From: Christopher Hobden [REDACTED]
Sent: 18 January 2011 19:07
To: Eve Hearsey
Subject: FW: Soldiers Field Stables Findon FN 83/10

From: Christopher Hobden [REDACTED]
Sent: 05 January 2011 09:21
To: [REDACTED]
Cc: Eve.Hearsey@arun.gov.uk
Subject: FW: Soldiers Field Stables Findon FN 83/10

Thank you for listening to the concerns we have about planning application FN 83/10.

Rev	Date	Description	By
Scale 1:100 @ A3			
Date Nov 2010			
Drawn GM			
Drawing Number 10/157/Sk03

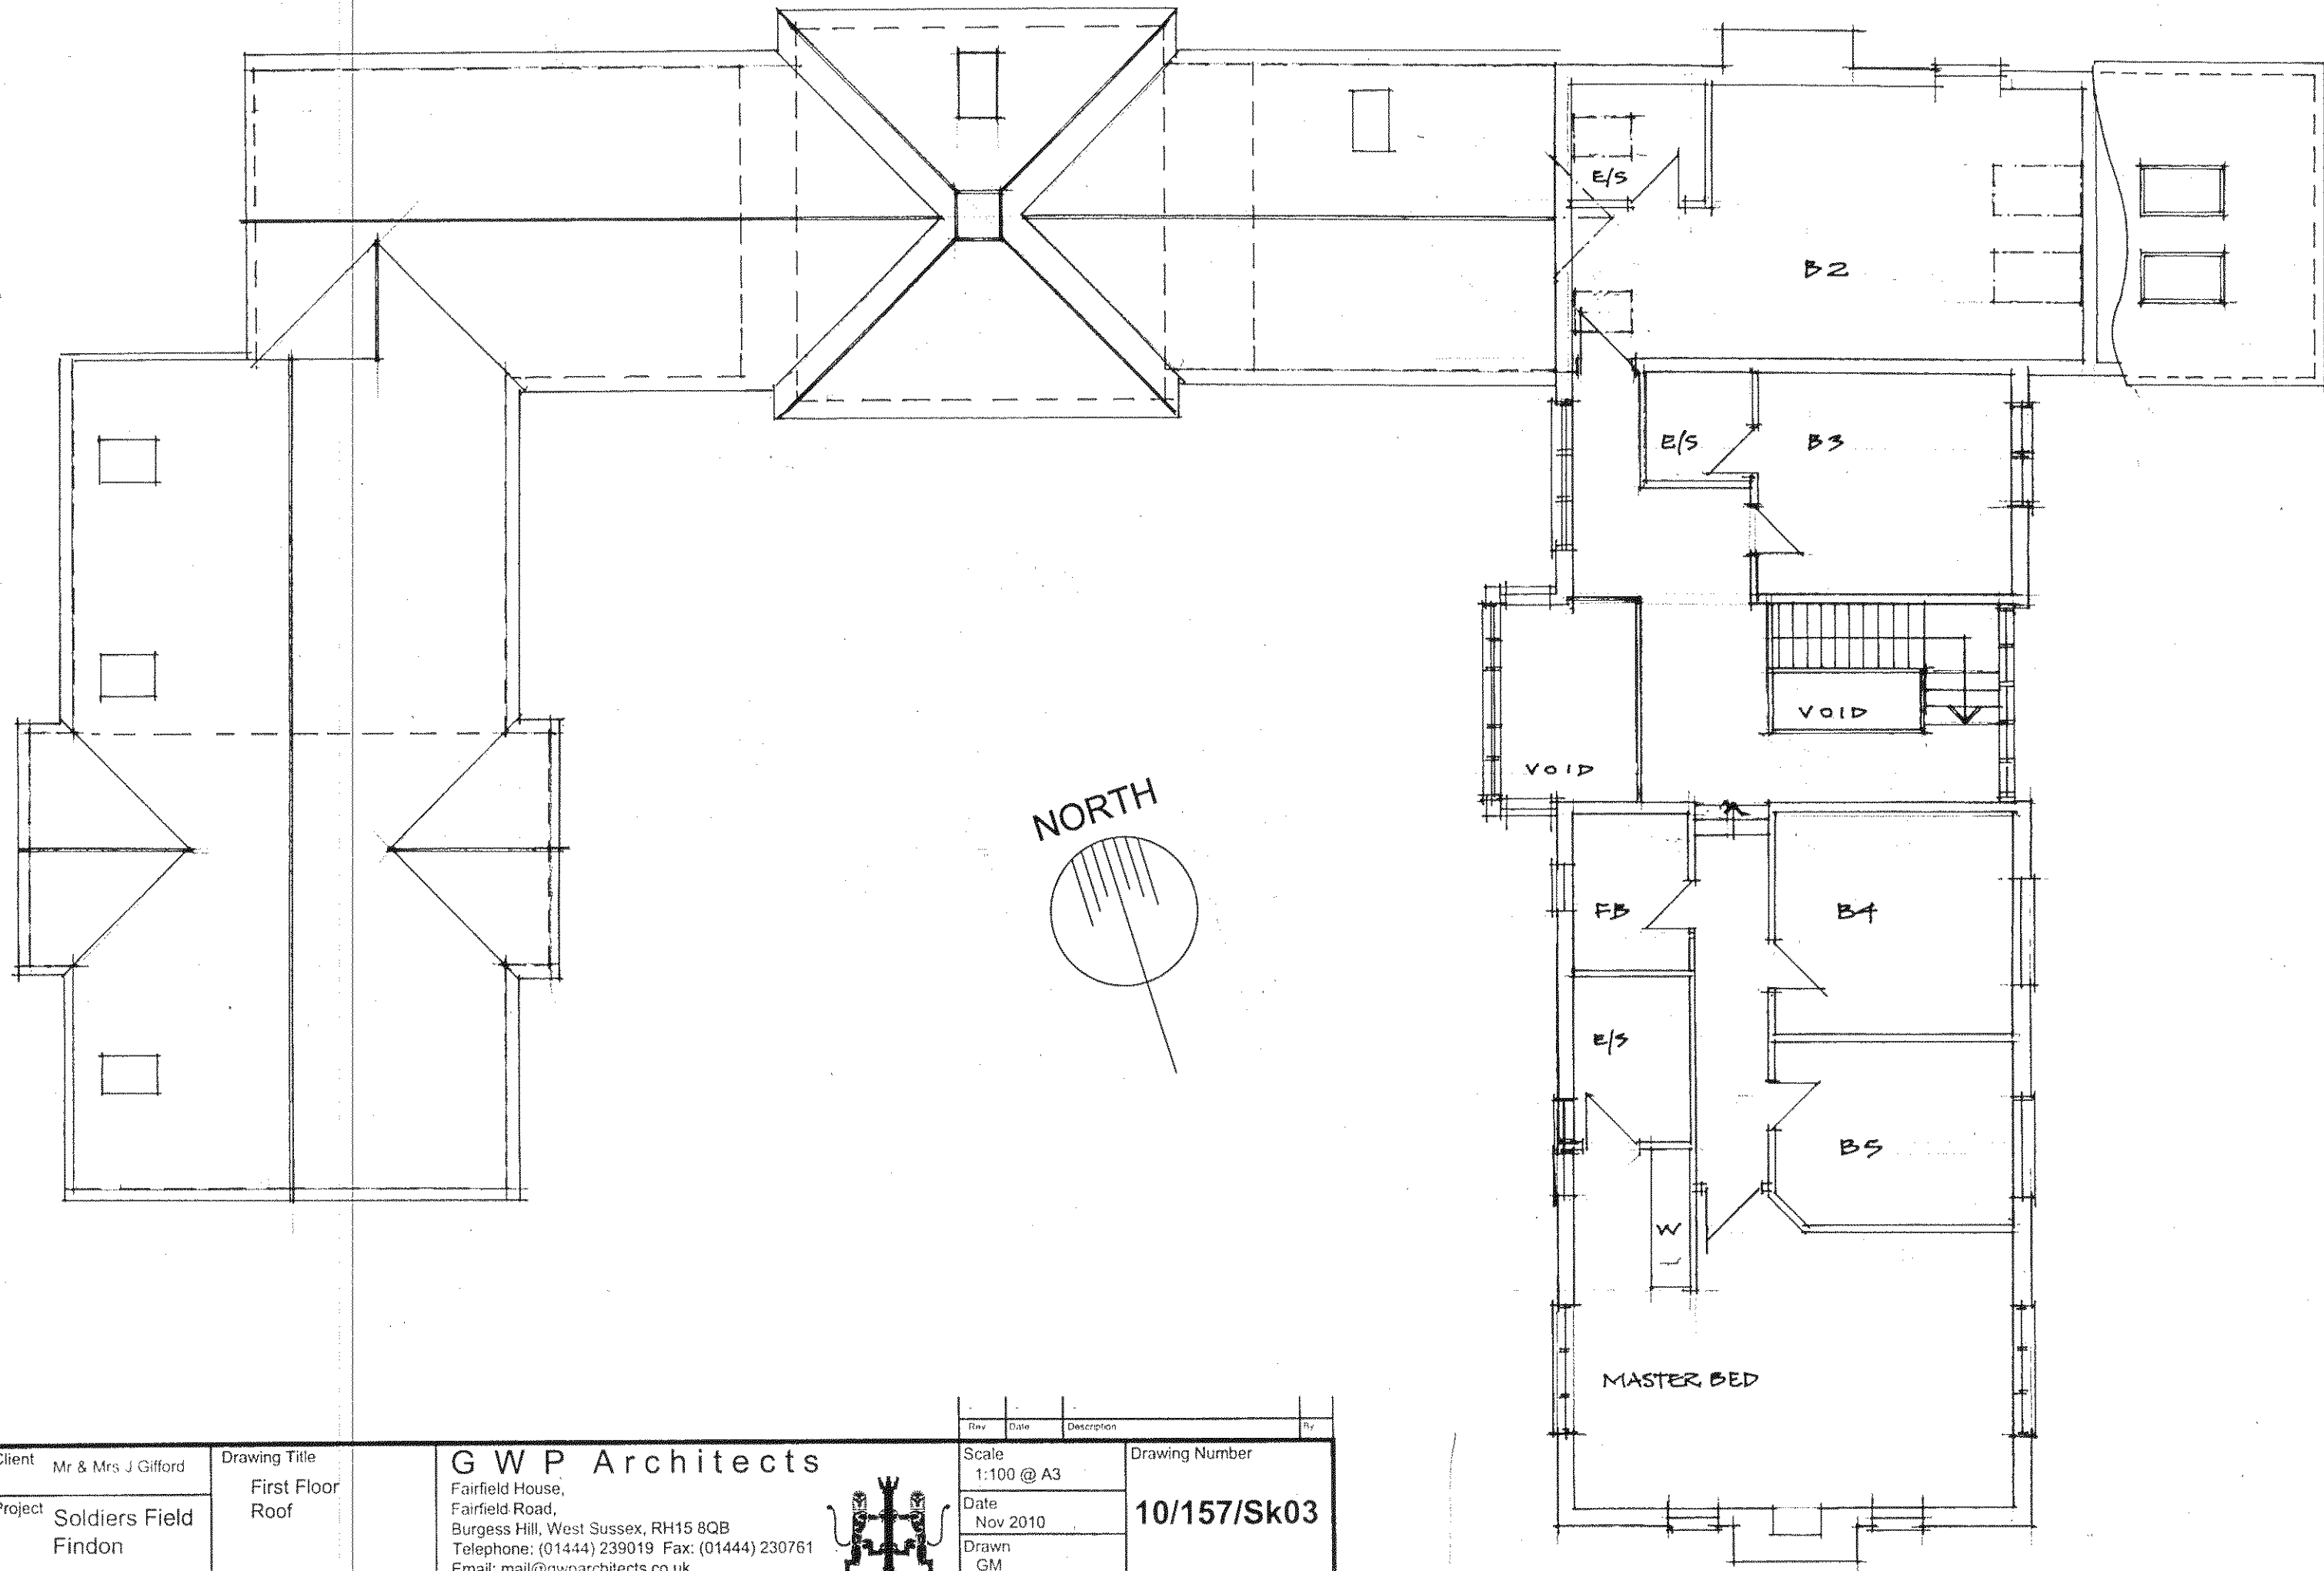
1. Drawing No.10/157/Sk03 shows 2 windows at first floor level in the southern gable end wall. These windows directly overlook our property, whereas in the planning consent already granted FN 37/09 there are no directly overlooking windows.

10/157/Sk06

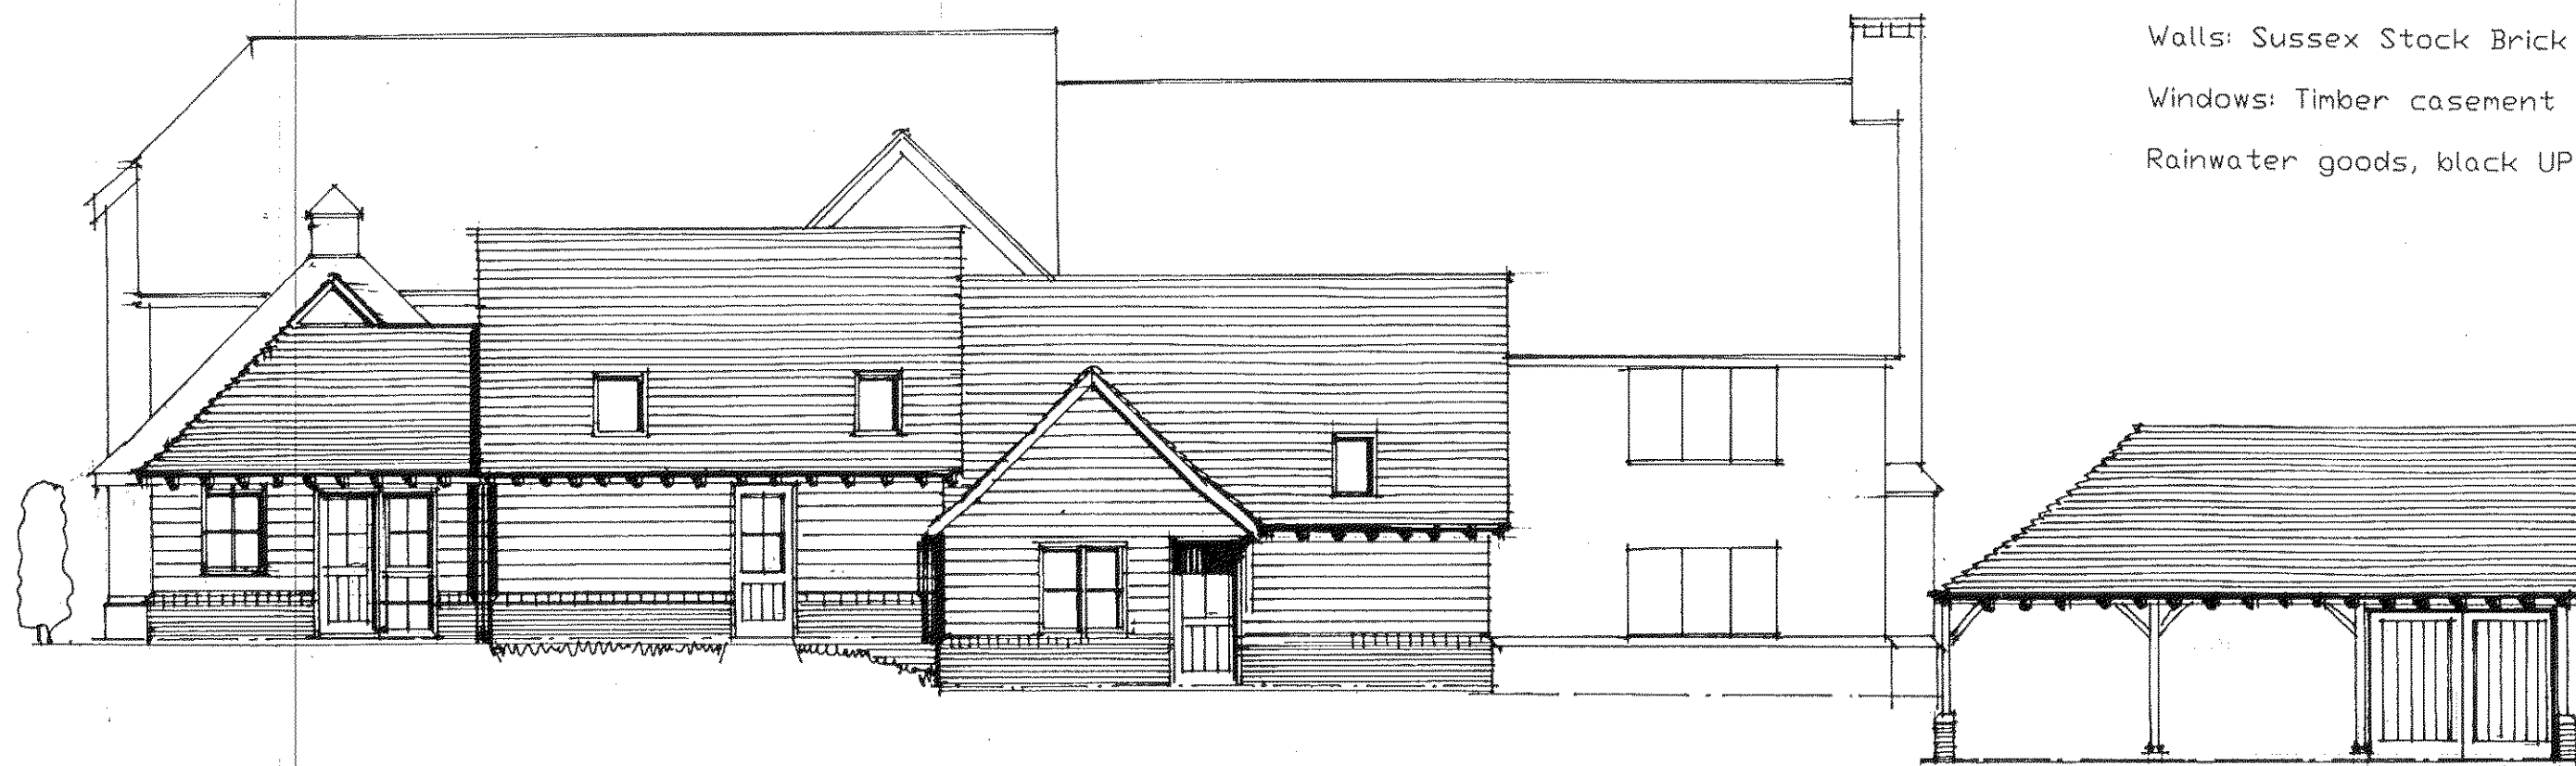
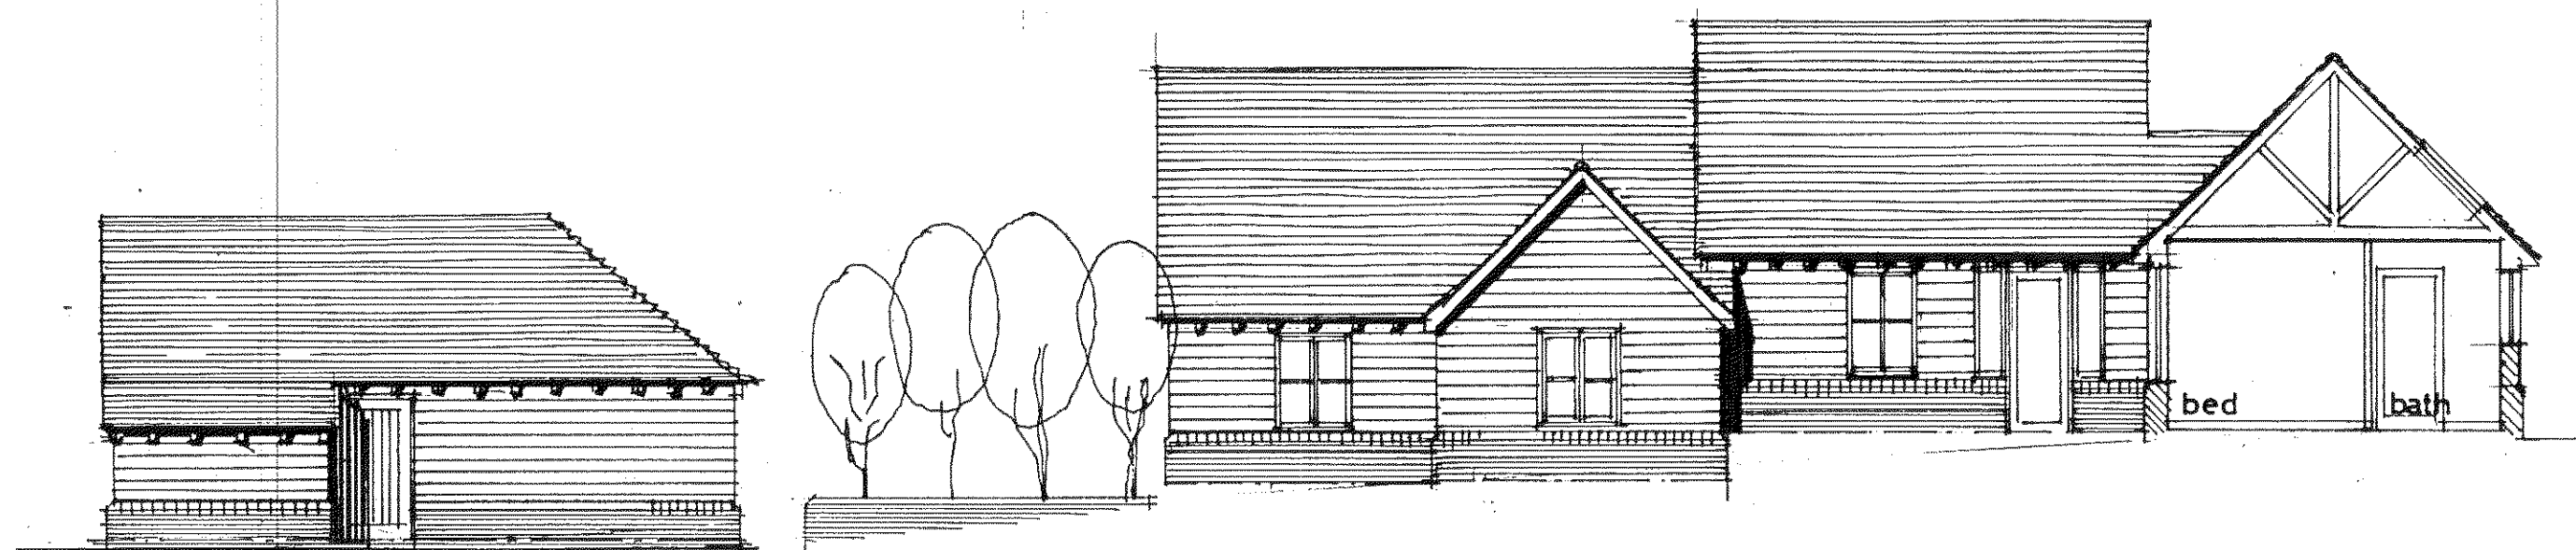
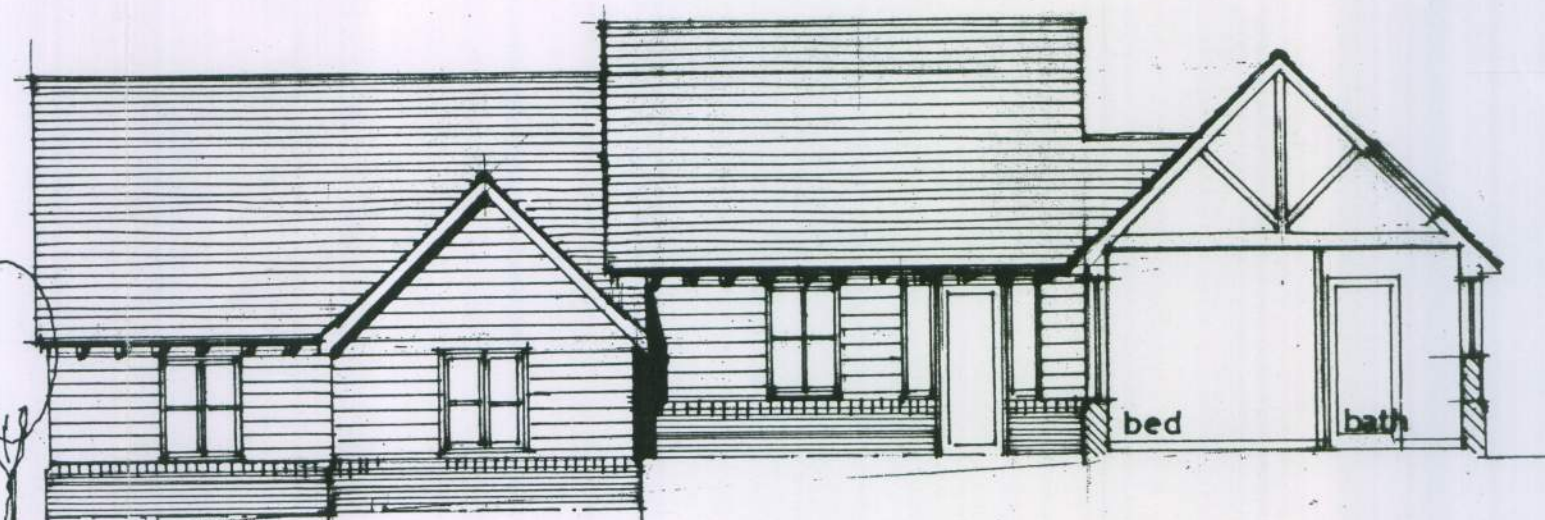
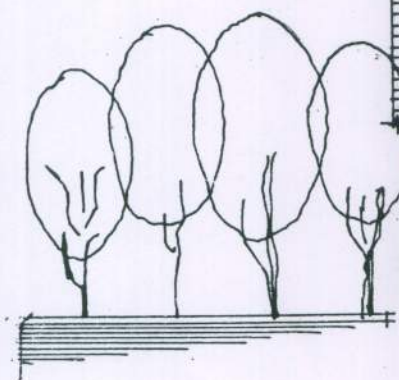
I forgot to mention one further point which we noticed on the plans. Drawing 10/157/Sk06 has the proposed garage on our boundary, which is fine, but we request that the pitched roof is hipped at the South end (to match North end) as this will reduce the height and visual impact of the new building on our boundary.

Thanks for your comments which are noted and agreed. I will tie up any similar minor "tweaks" and liaise further with Eve Hearsey.

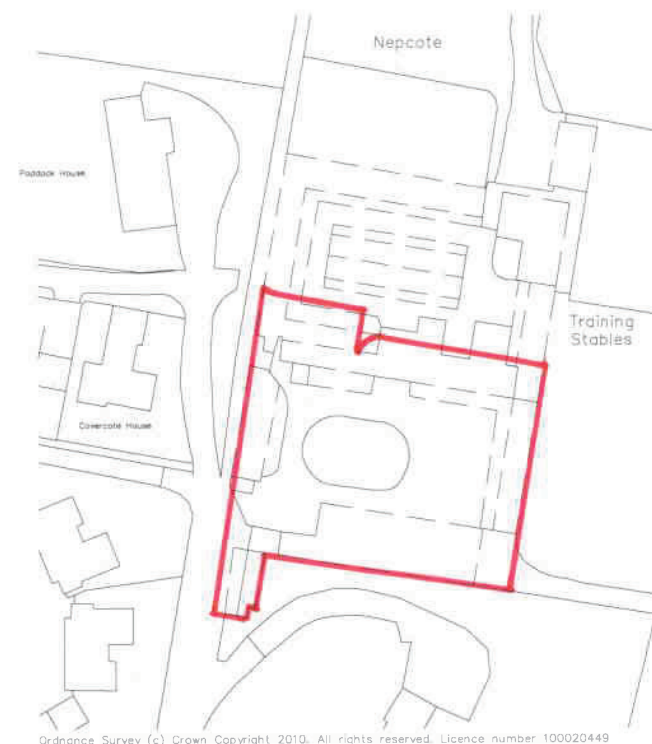
3. FN 37/09 has the Bin Store building to the south of the main entrance. FN 83/10 (Drawing No.10/157/Loc) does not replicate this but shows the existing single storey building in that location demolished. Again the rear wall of this existing building defines the boundary between your client's property and ours and if it is to be demolished, please specify the design treatment you propose for the new boundary fence or wall.
